From: Tendai Pindeni <Tendai.Pindeni@arun.gov.uk>
Sent: 05 January 2021 16:22
To: Planning.Responses <Planning.Responses@arun.gov.uk>; Andrew Wood <Andrew.Wood@arun.gov.uk>
Subject: RE: Planning Consultation on: FG/149/20/PD

Application No: FG/149/20/PD

Registered: 13th November 2020
Site Address: 11 Sea Lane Ferring BN12 5DR
Grid Reference: 509514 102817
Description of Works: Prior notification under Schedule 2, Part 3, Class O of the Town & Country (General Permitted Development (England) Order (as amended) for the change of use of the existing first floor of the building from office (Class B1(a)) to 4 No. residential dwellings (Use Class C3) .

Proposed floor plans

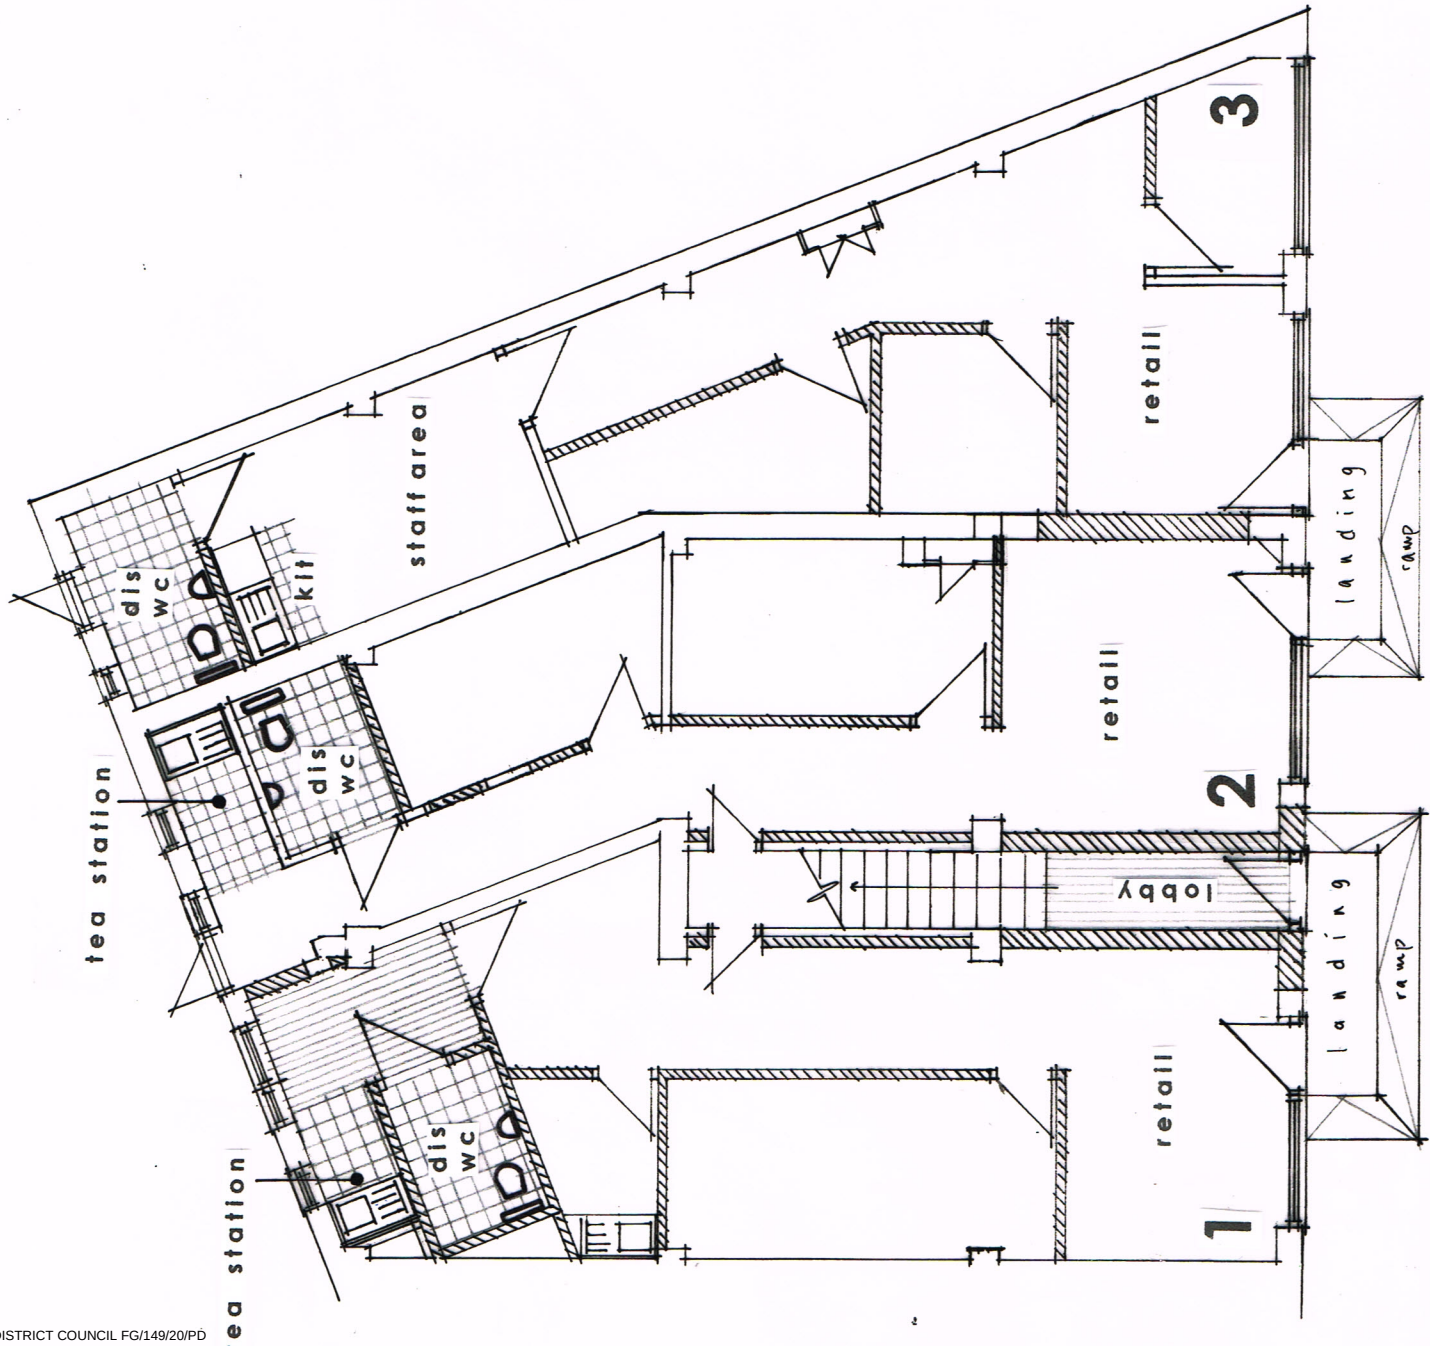
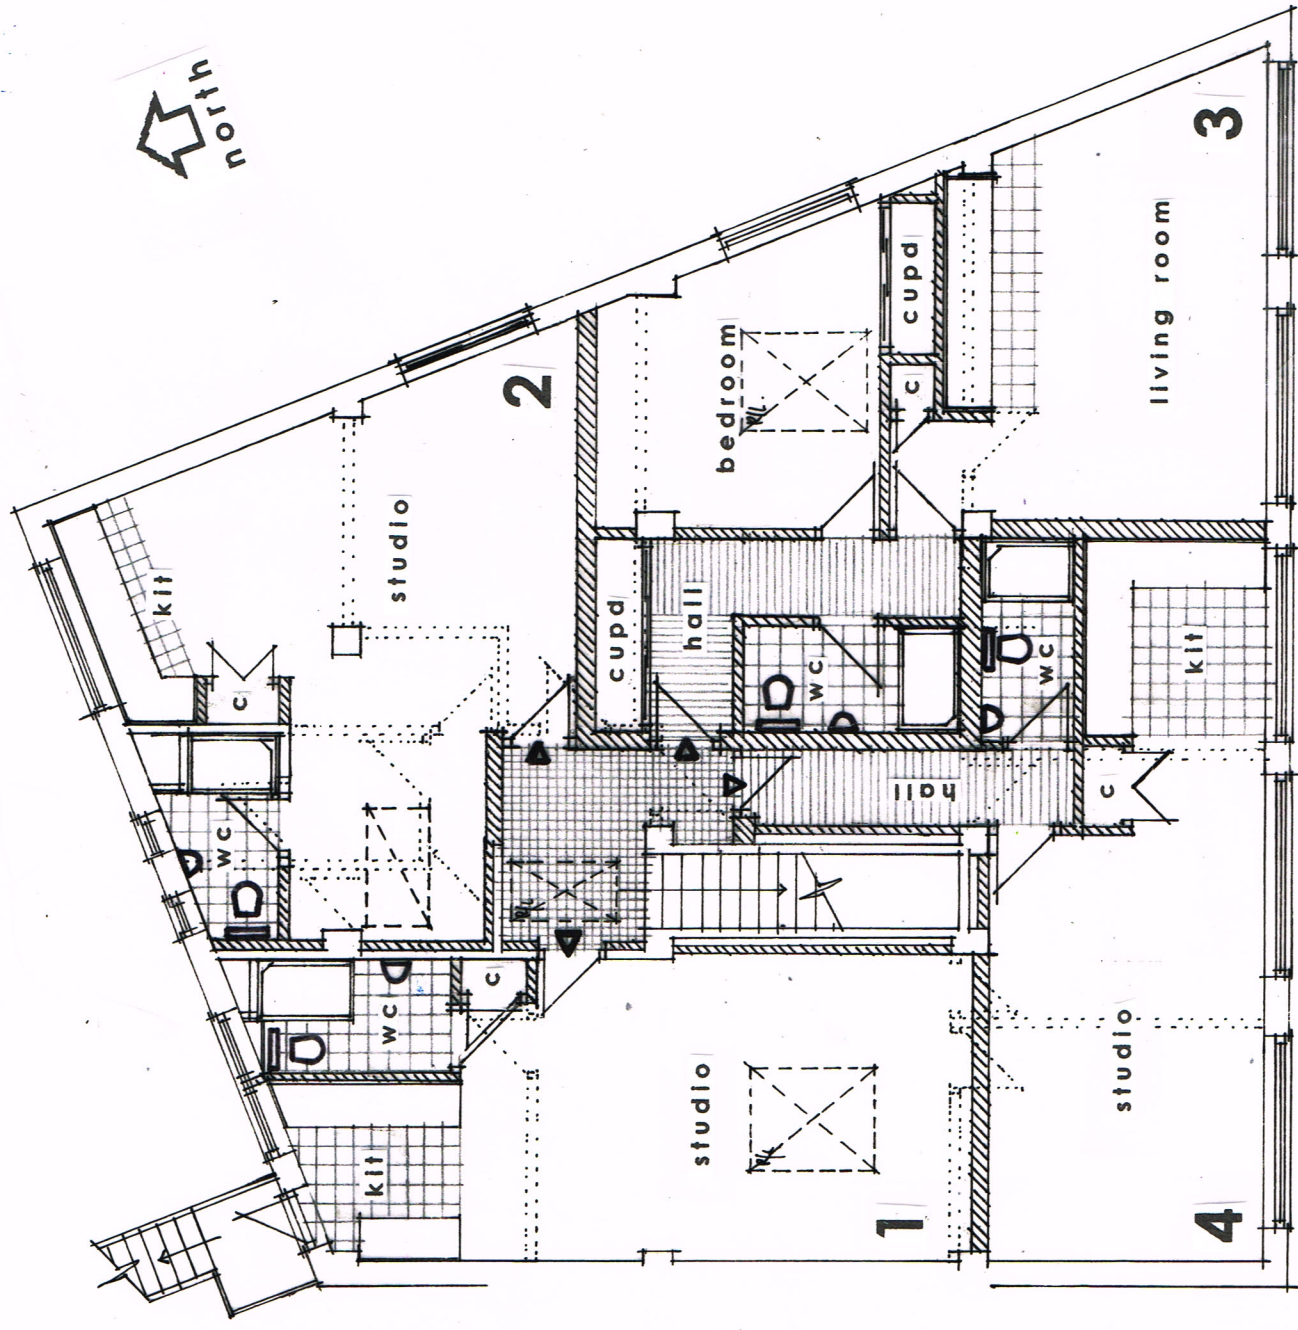
Sound Insulation

The sound insulation of the floor / ceiling between the ground and first floor shall achieve a minimum airborne sound insulation value of 50 dB ($D_{nT,w} + C_{tr}$). Before the residential unit is occupied, a test shall be undertaken by a competent acoustician and submitted to the Local Planning Authority to demonstrate compliance with this level.
